From: Nolan, Chris <Chris.Nolan@lancashire.gov.uk>
Sent: 22 September 2017 09:00
To: Rebecca Halliwell; planning
Cc: LHS Customer Service
Subject: D3.2017.0862 - Millstone House Waddington Road West Bradford

Planning Application No: 3/2017/0862

Proposal: Proposed installation of new electrically operated gate fixed to the rear side of the existing wall.

Location: Millstone House Waddington Road West Bradford Lancashire BB7 4SX

**Drawing Title:** Proposed Electrically Operated Gate

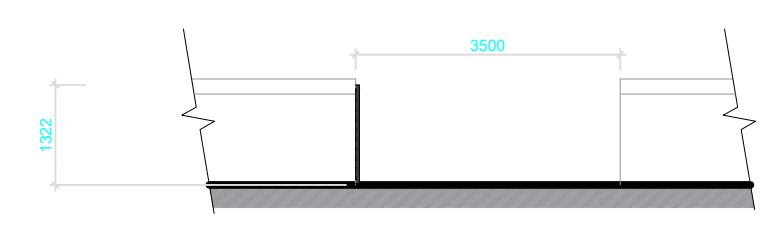
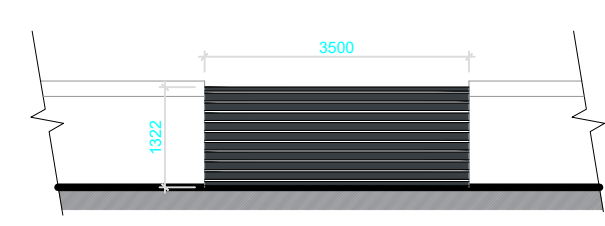
With regard to the above planning application to fit an electrically operated gate to the rear of the existing wall. I can appreciate that this is a reasonable solution to the problem of using this former garden area for parking. However I do have some concerns with regard to the sightlines for vehicles leaving the parking area. Normally for a situation of this type I would request that the walls were reduced in height to 1 metre or less so that drivers could see over the wall from a normal driving position, vastly improving the minimal sightlines that are presently available.

Due to the existing wall, that is likely to be as old as Mill Stone House, and the historic layout of the village I would not raise objections to this application but I would ask the client to consider lowering the height of the wall either side of the entrance to improve the safety of vehicles entering and leaving the parking area.
